# STERLING RANCH - VOLLMER ROAD FILING 2

## STREET IMPROVEMENT PLAN

APRIL 2021  
CDR 20-005

**VOLLMER ROAD
STA 10+00.00 TO STA 23+50.00**

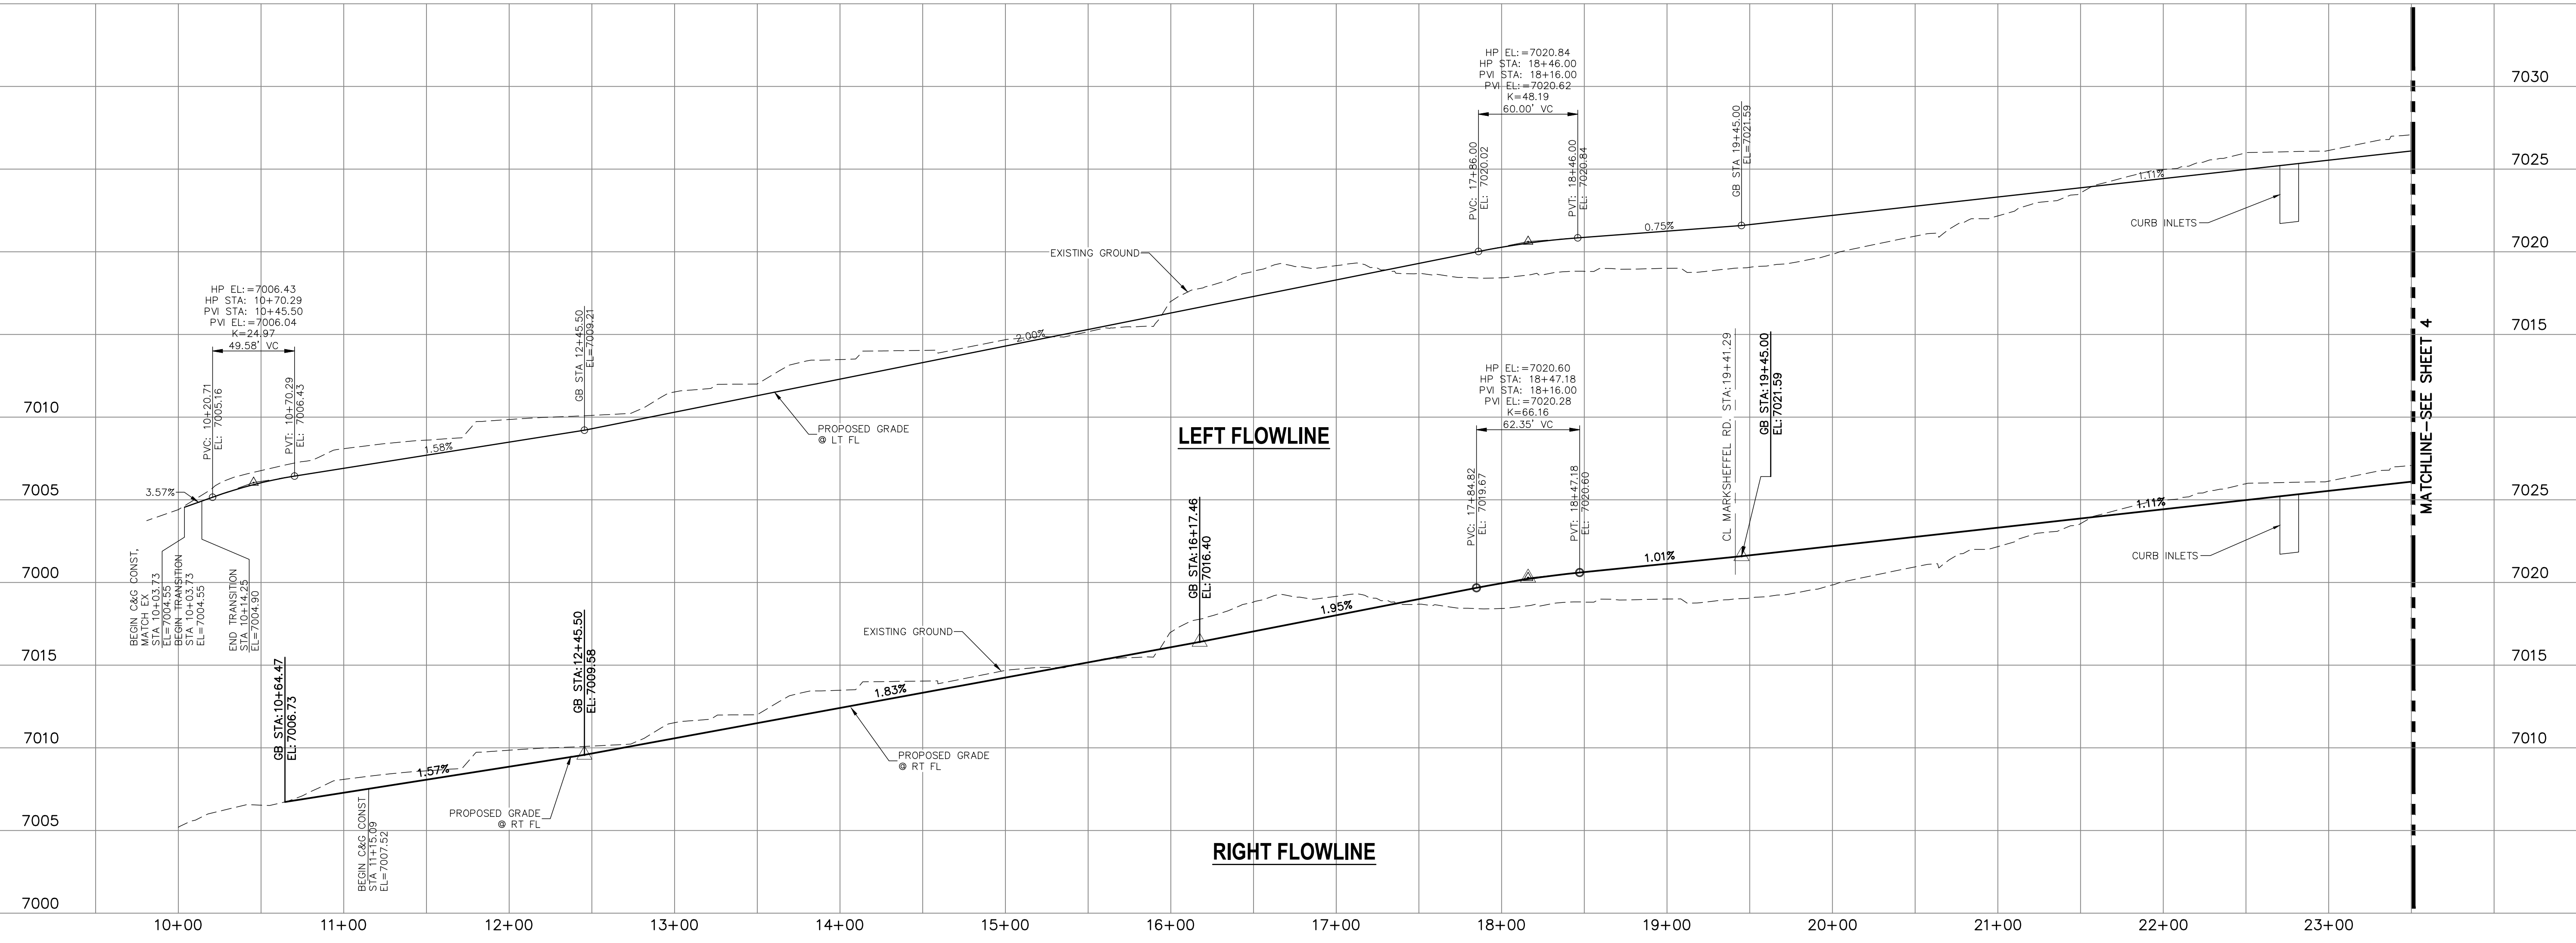
Please place inlet along extension of turn lane in case it ever needs to be lengthened, with a short chase.
